# ENG-SF18025-R1-Plat\_Redlines.pdf Markup Summary

# ENG-SF18025-R1-FDR\_Redlines.pdf Markup Summary

# ENG-SF18025-R1-CDs\_Redlines.pdf Markup Summary

SF-18-025

TYPICAL ROAD SECTIONS

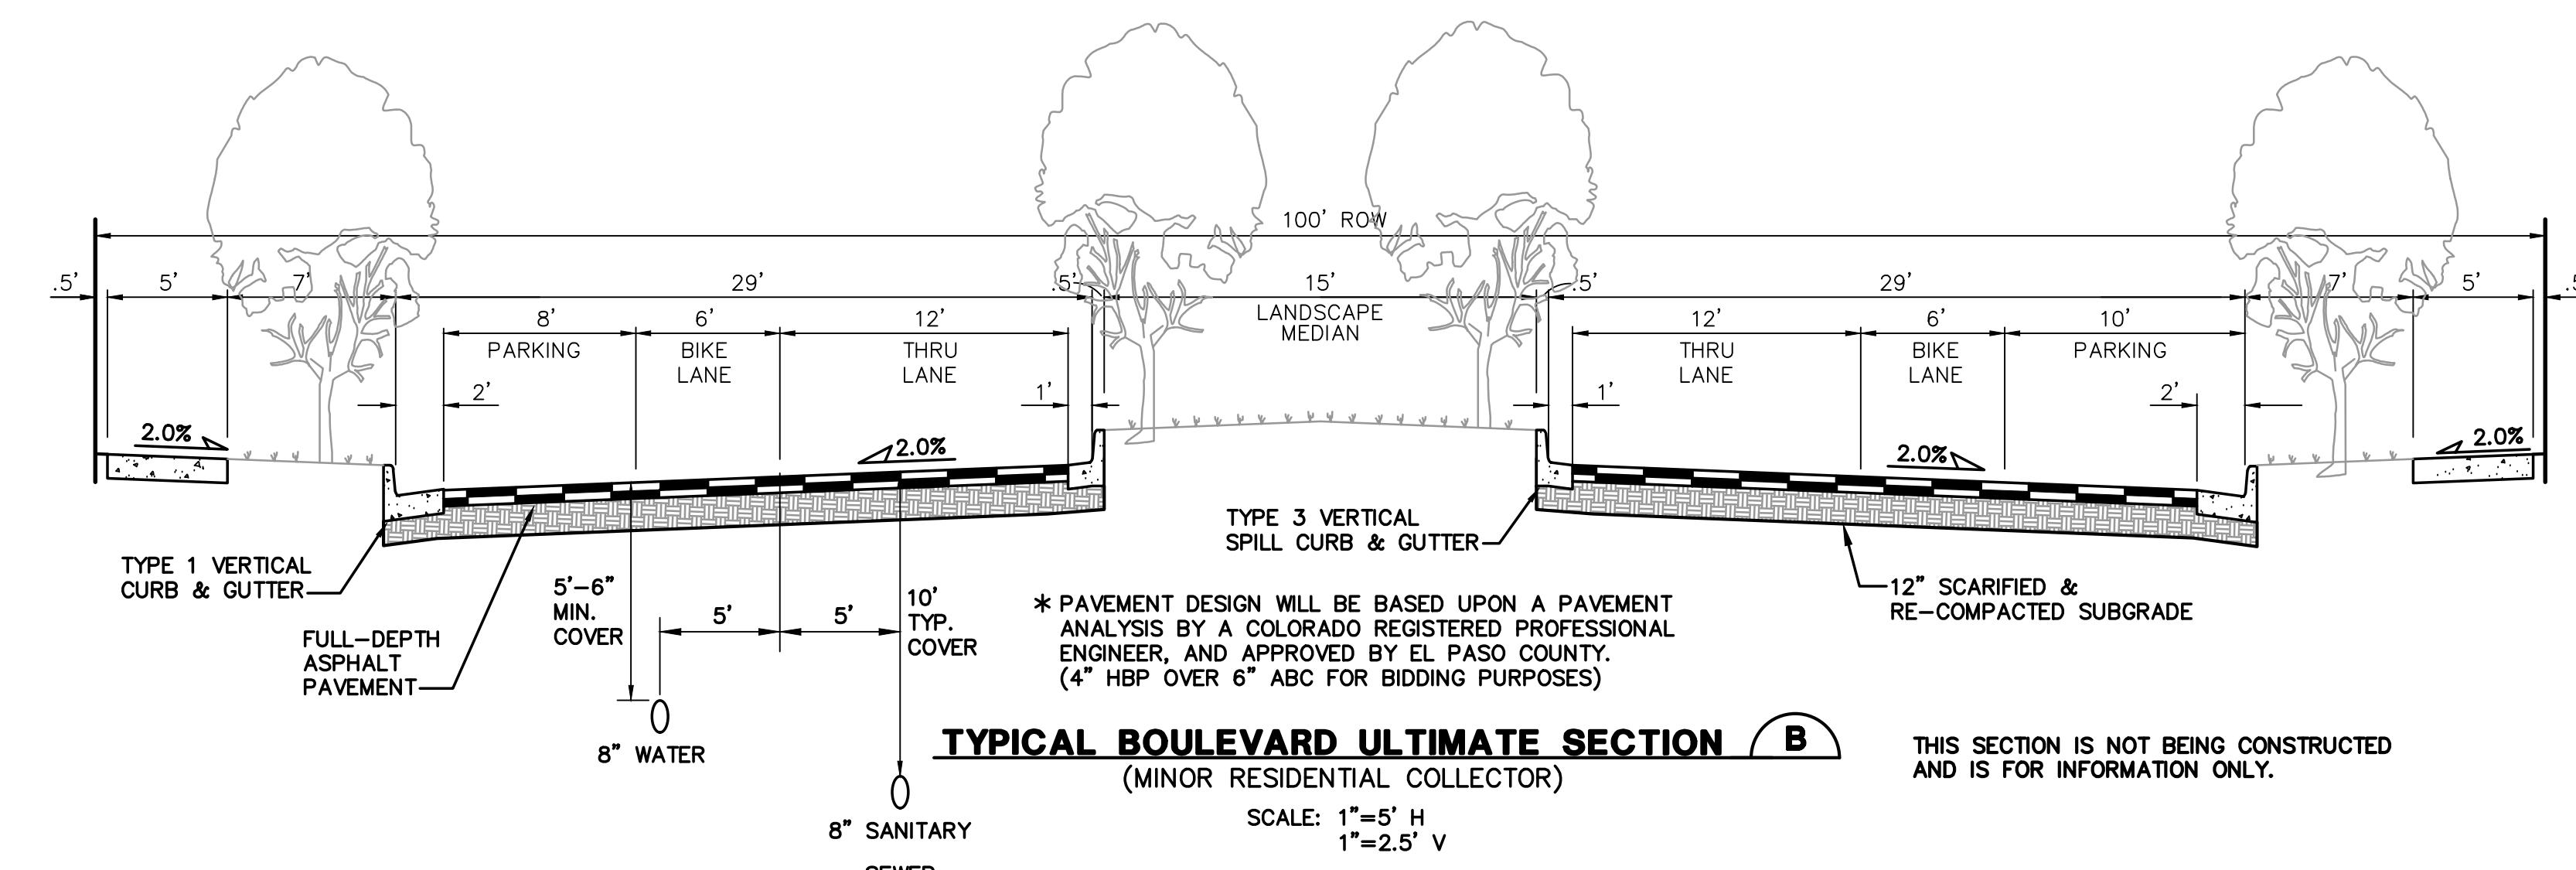
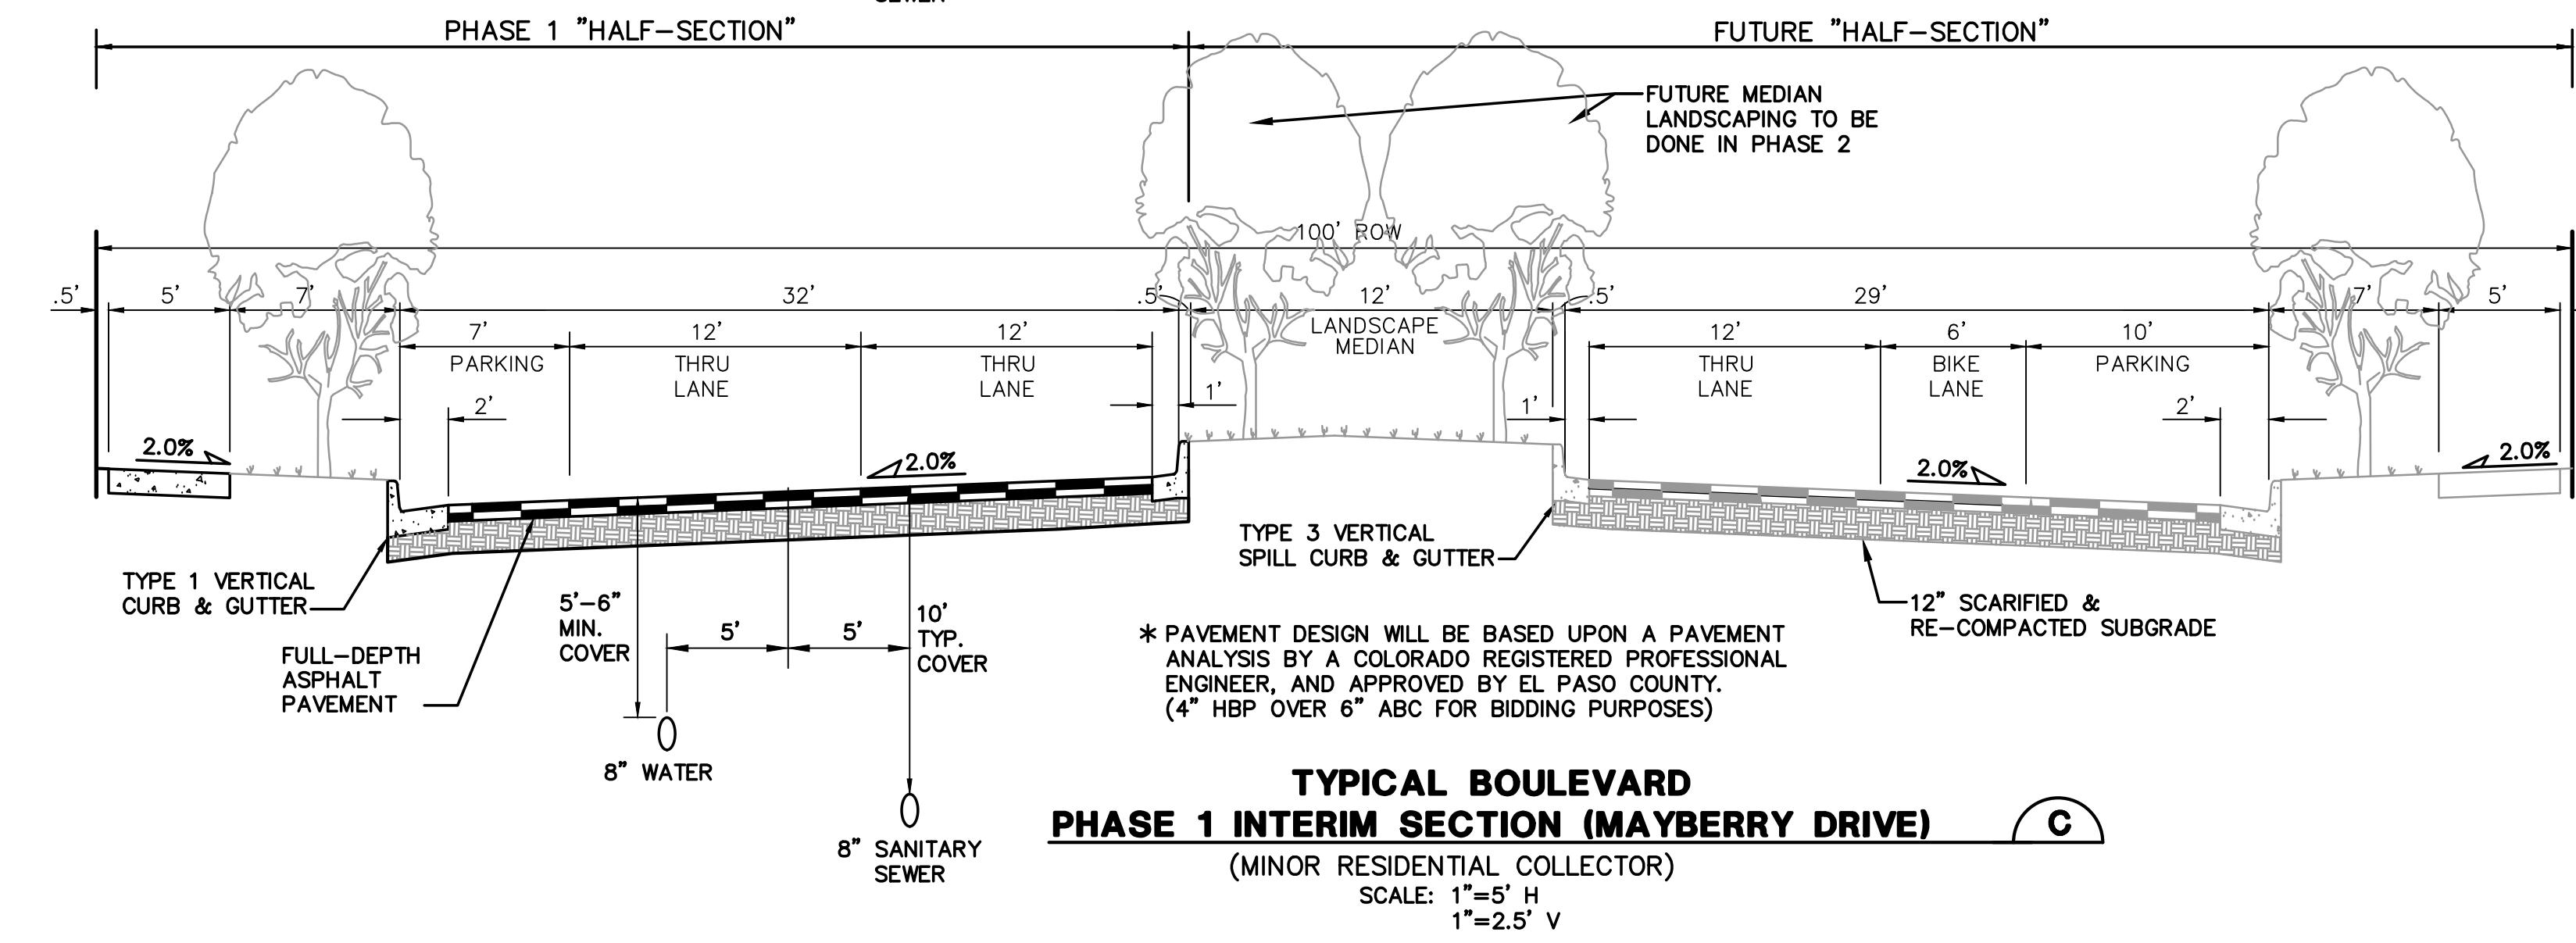
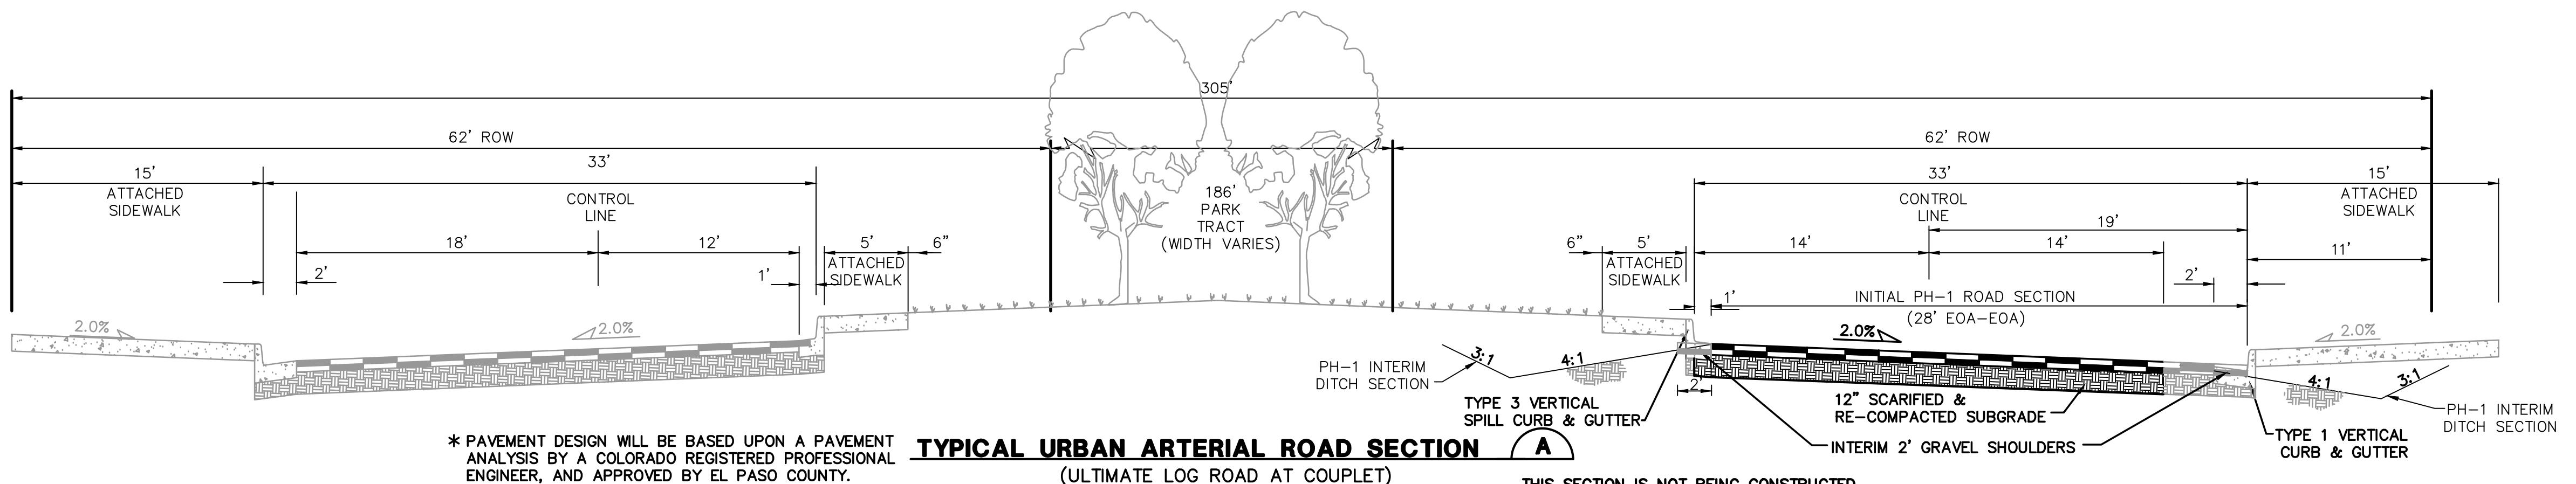
Full-depth is not allowed; verify that FAE costs are adequate for all classifications.

Overlay XS F/TY1 for information. This may be done as a separate exhibit.

Revise. Lanes need to be 12', not including gutter.

Dimension all lanes to edge of pavement, not curb.

Is median landscaping included?
